-----  
Letter No.C2/24222/90, dated 4-7-'91

Sub: MMDA - Planning Permission - Proposed  
Construction of Factory building at  
P.No.A2, Mogappair Industrial Estate  
Village - Planning Permission issued  
leased on Local Body Earlier approved -  
Plan regarding.

- Ref: 1) Planning Permission No.5136/86,  
dated 28-10-'86 of Ambattur Township.  
2) Re.No.5839/90/F1, dated 11-9-'90  
from Ambattur Municipality.

PROPOSED INSTALLATION OF MACHINERIES FOR M/S LAVANYA PRINTING INKS
 For LAVANYA PRINTING INKS.
 Proprietor.

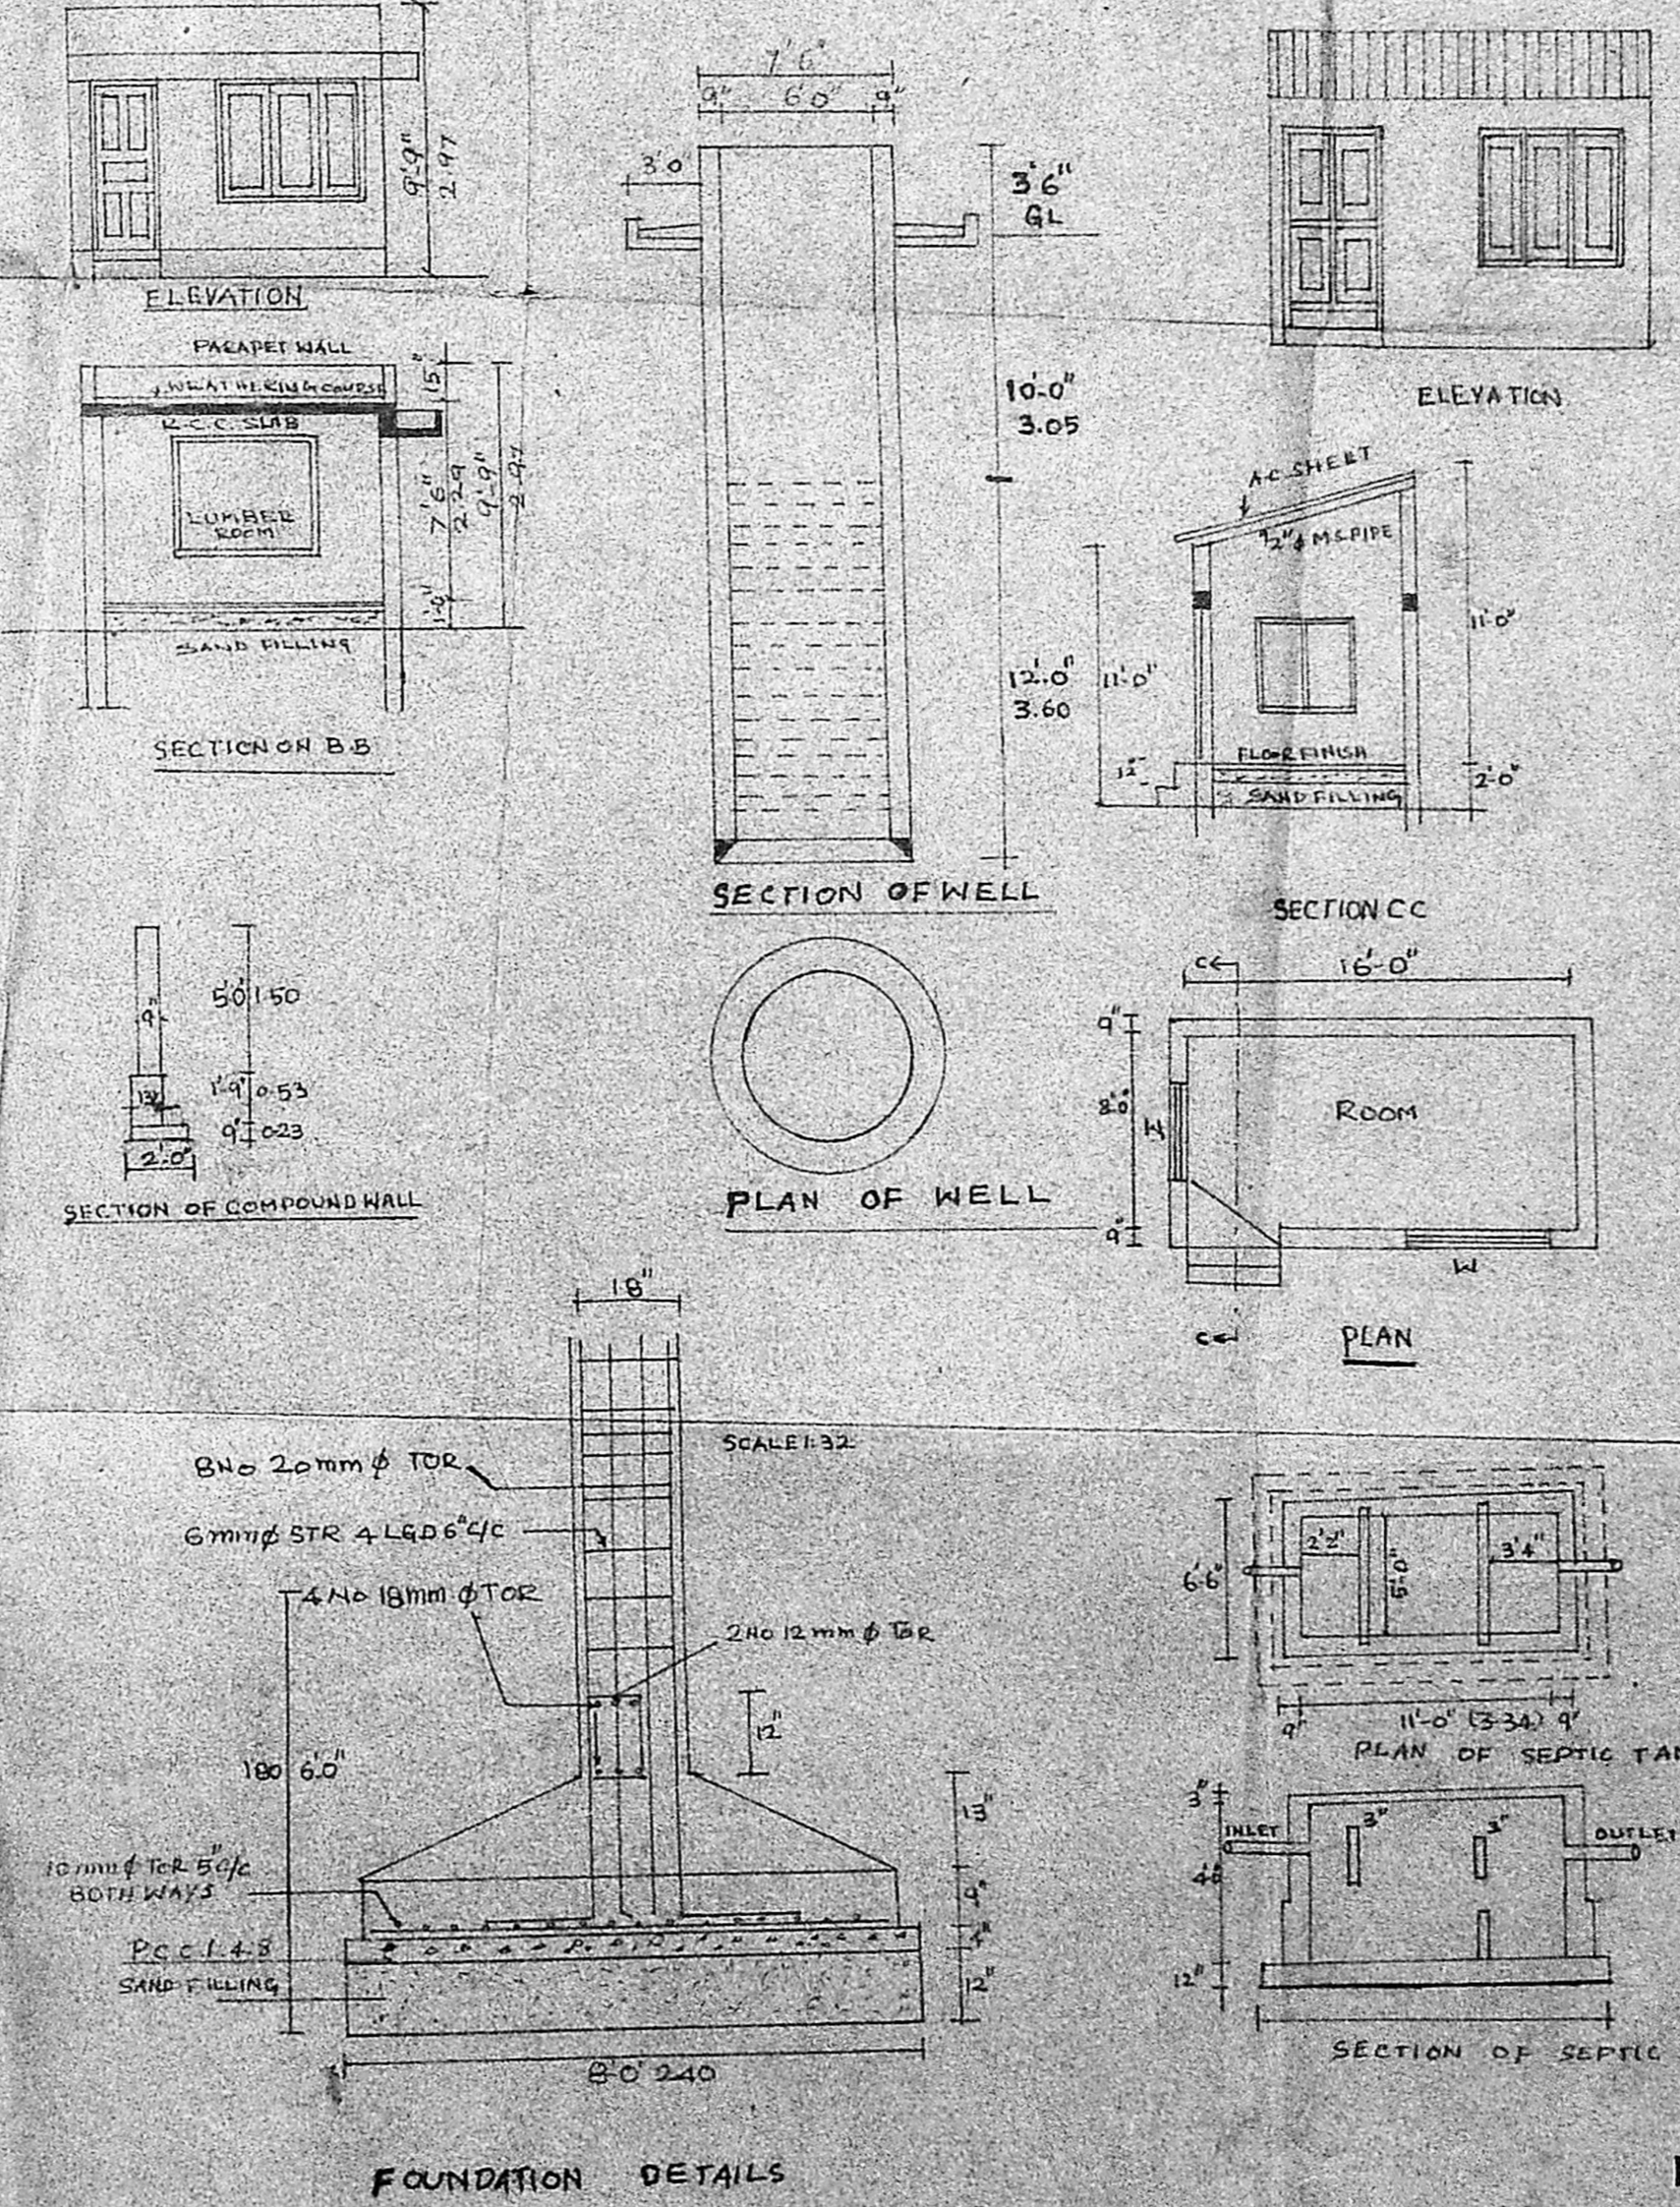
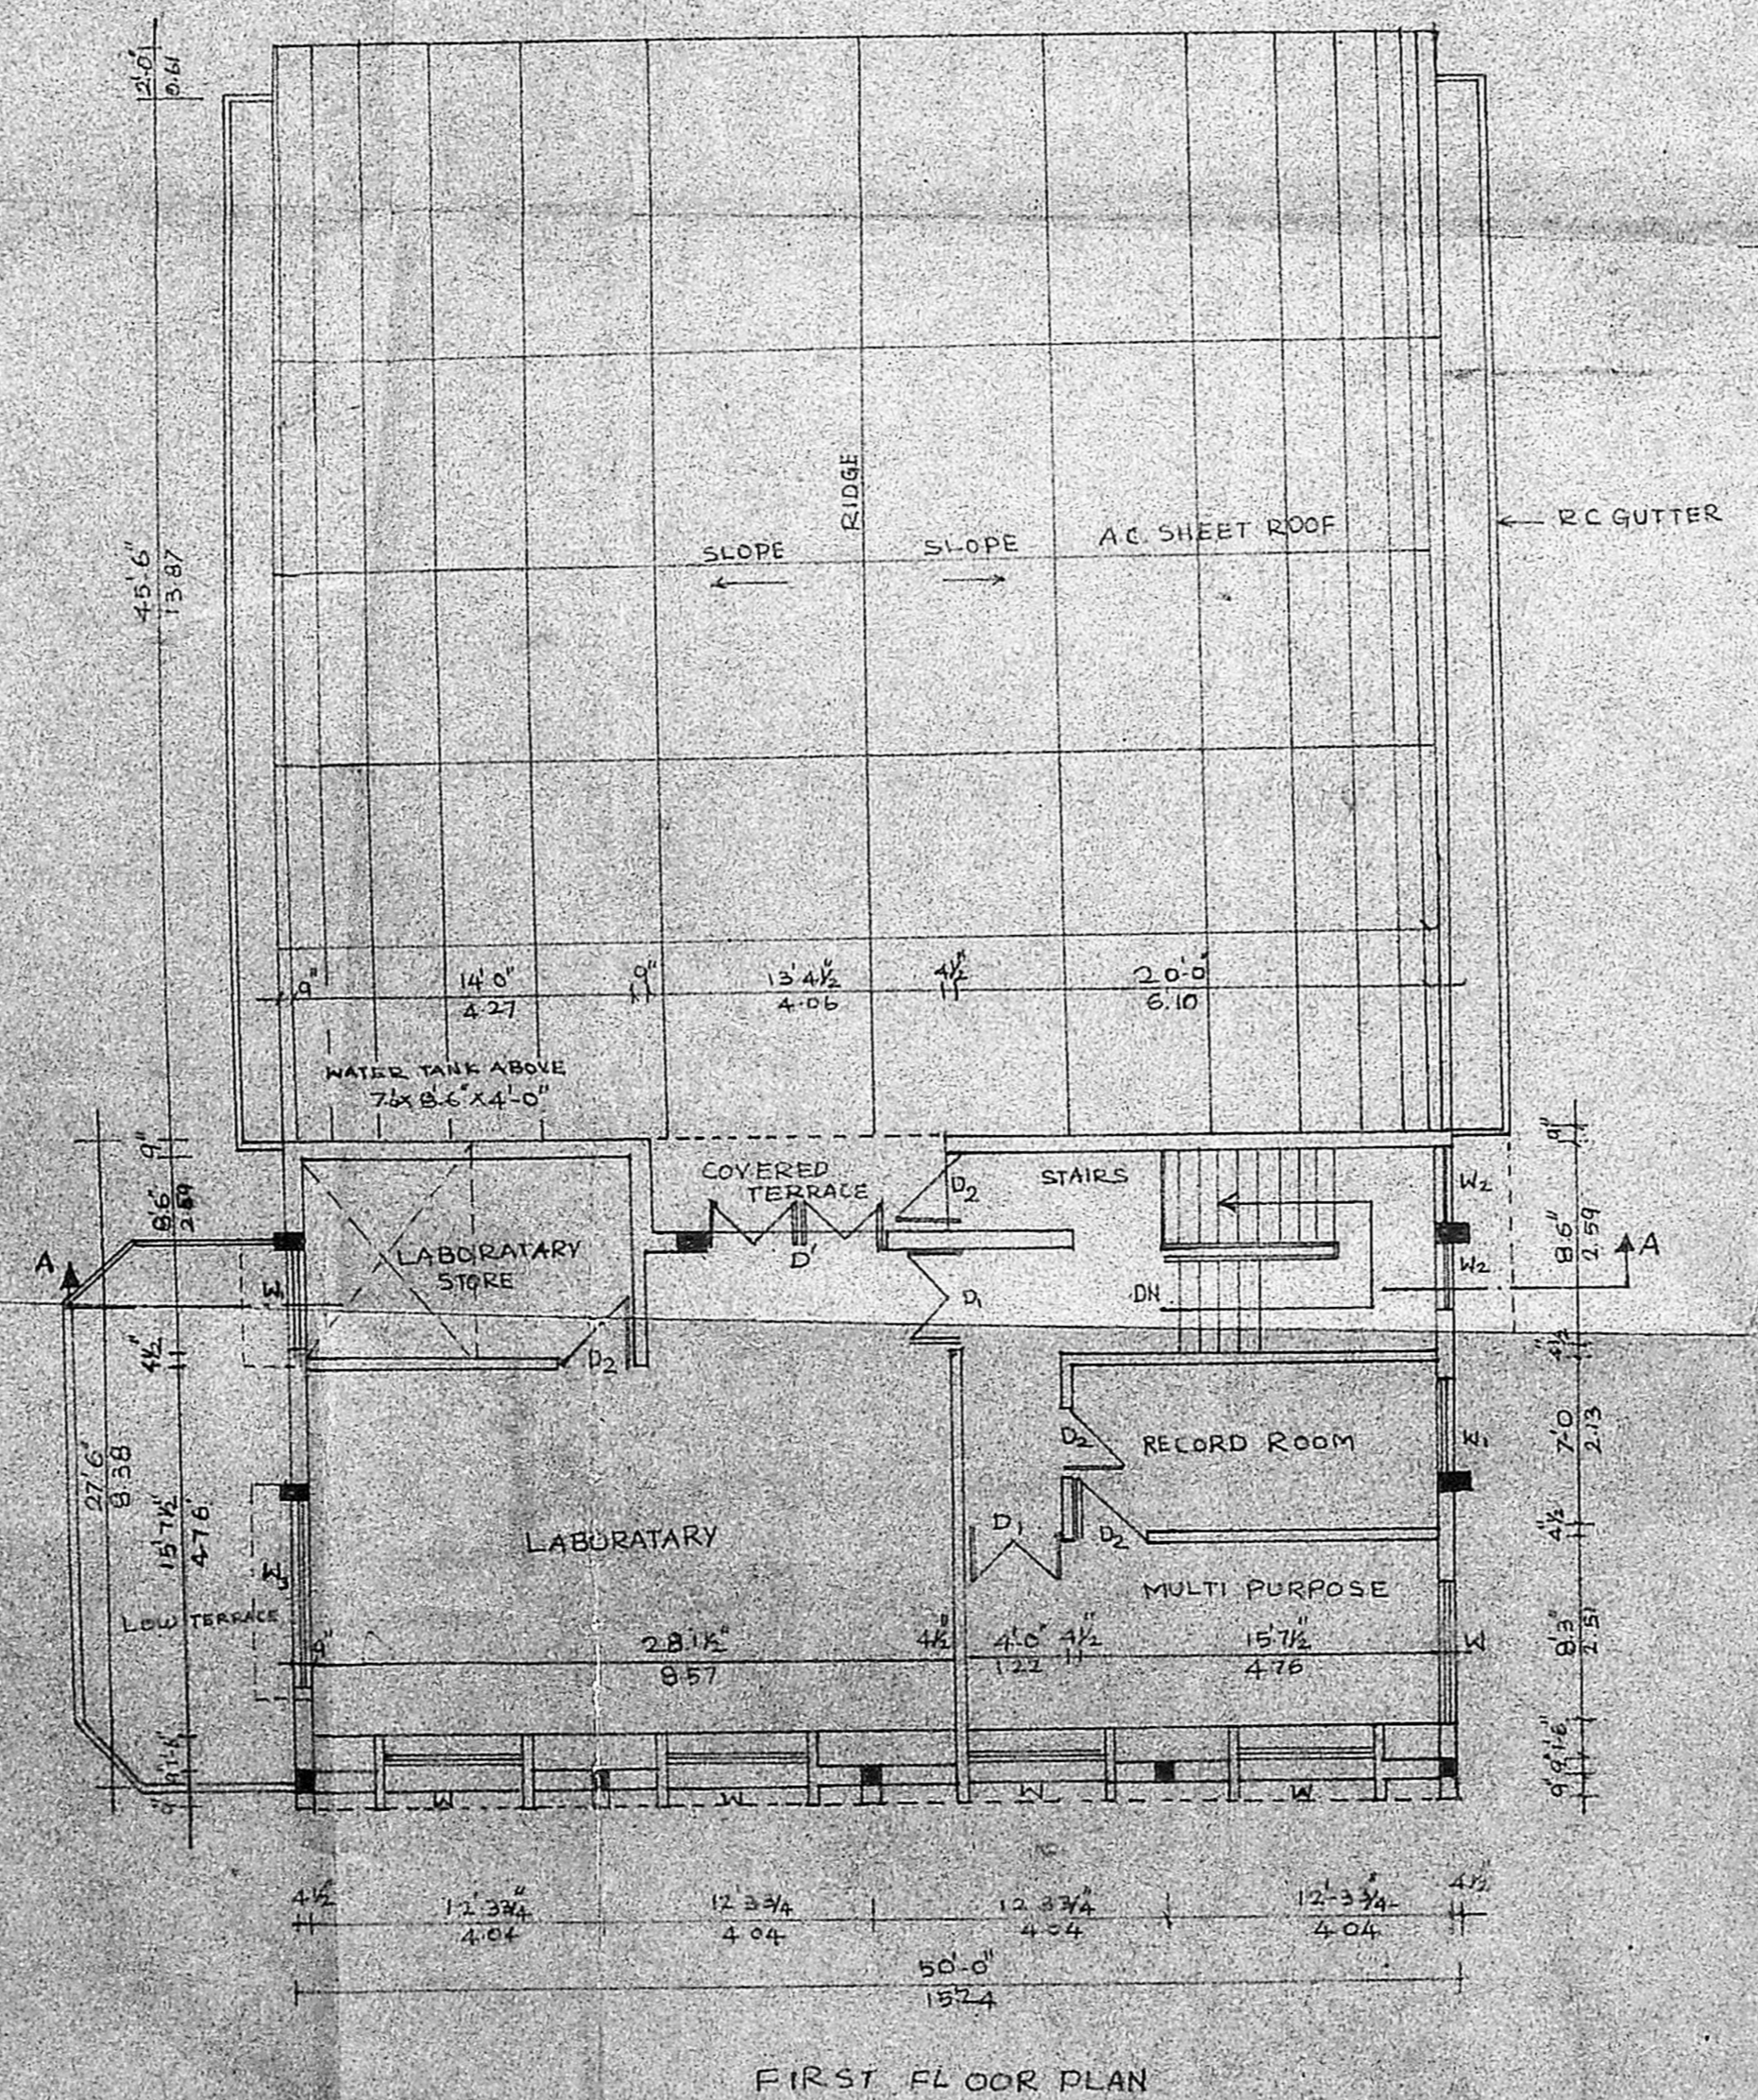
I invite your kind attention to the reference 2nd cited,  
wherein the Commissioner, Ambattur Municipality has submitted a  
Planning Permission Application of M/s. Lavanya Printing Inks  
at Plot No.2, Mogappair Industrial Estate for the proposed  
installation of 25.5HP.

2. While Scrutinising the paper, it has been found  
that the Ambattur Municipality has already issued a Planning  
Permission (reference 1st cited) for the construction of the  
Industrial building for manufacturing ink to ~~comparing~~ in *Said*  
violation of Development Control Rule 11(d) Parameter and *Company*  
Front Set Back and side set back requirements. Since the  
construction, have already been approved by Local Body violating  
the Development Control Rule, Para Meters, this Authority has  
been forced to an embarrassing situation of approving the installation  
of electric motors in the said premises.
